WISWELL PARISH COUNCIL

Planning Application No: 3/2012/0346
Outline Application for mixed B1, B2 and B8 industrial use including access
Land off Hey Road, Barrow, Clitheroe, Lancashire, BB7 9WA

ILLUSTRATIVE SITE LAYOUT			
Site: Barrow Brook Business Village Chilfence			
Client: Edward Hine LPA receiver for Papillon Properties Ltd			
Date: 21.01.13	Scale: 1:500 @ A0		
Project No: HINE/02 Dwg 03A	Drawn: RJ		
Amendments:	A

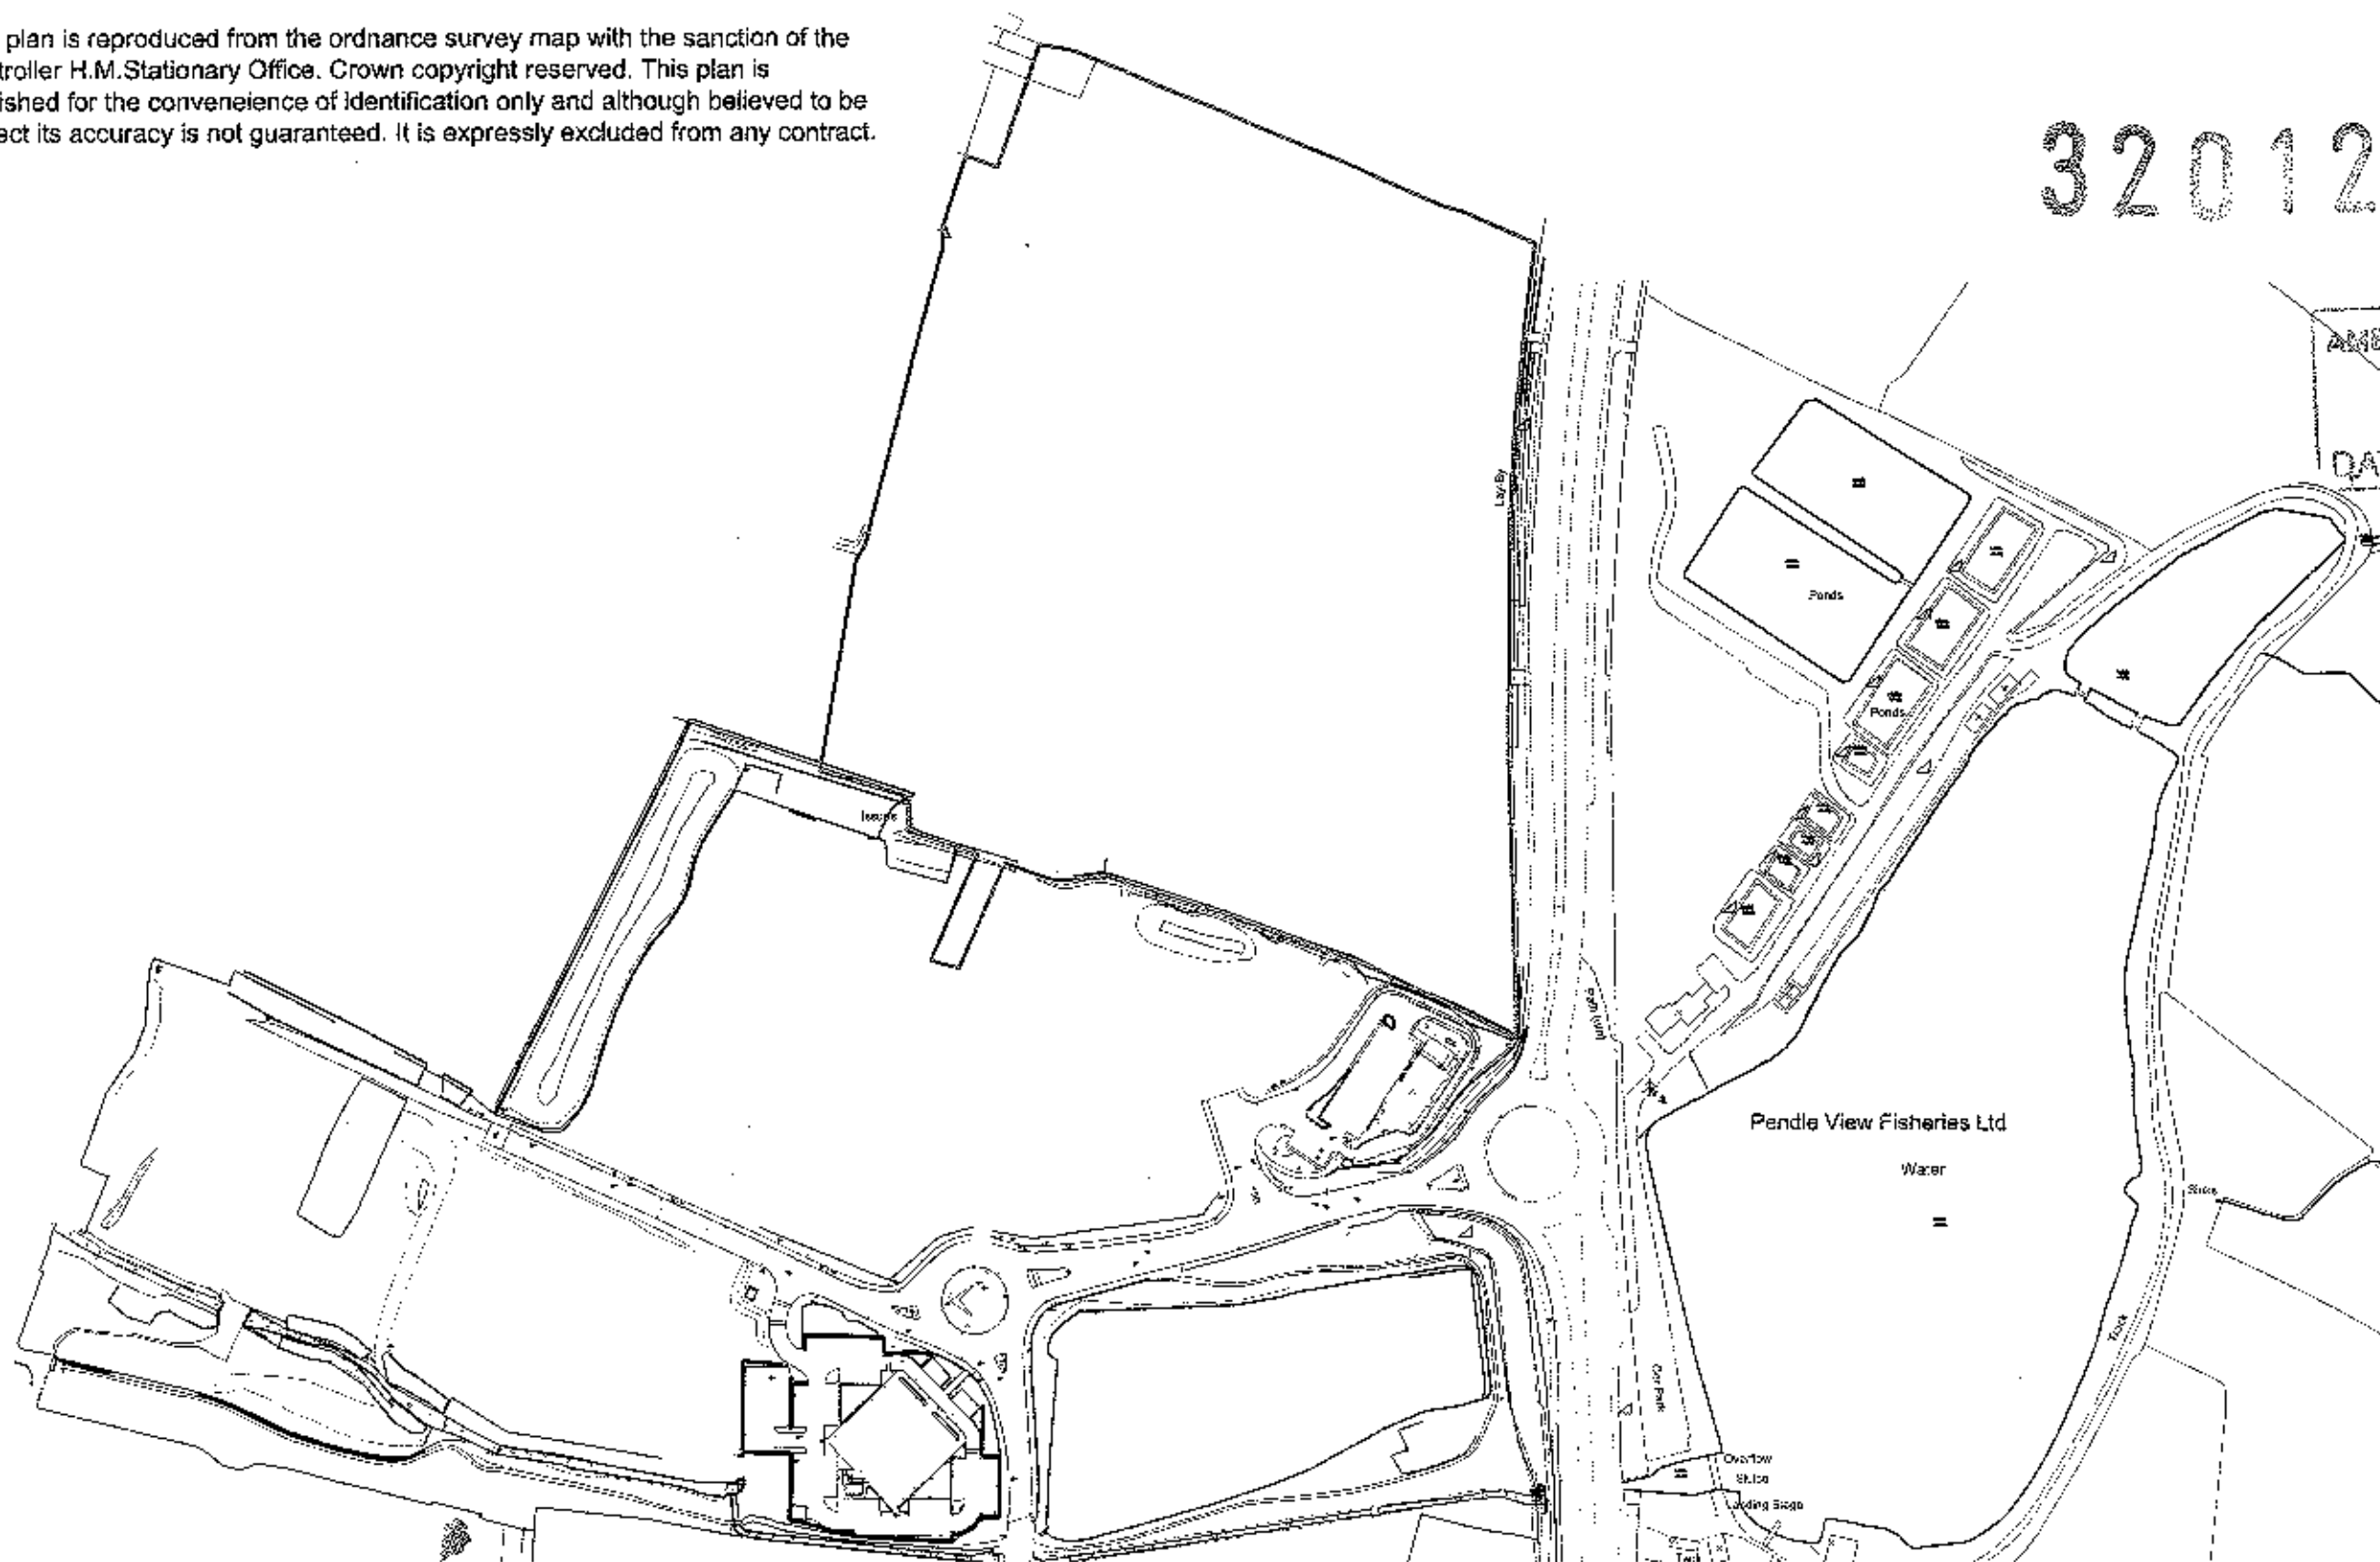
Further to the Parish Council's letter dated 23rd May 2012, Members have asked me to point out that a public footpath runs across the land contained in the planning application and the footpath must be retained in its present position for future use.
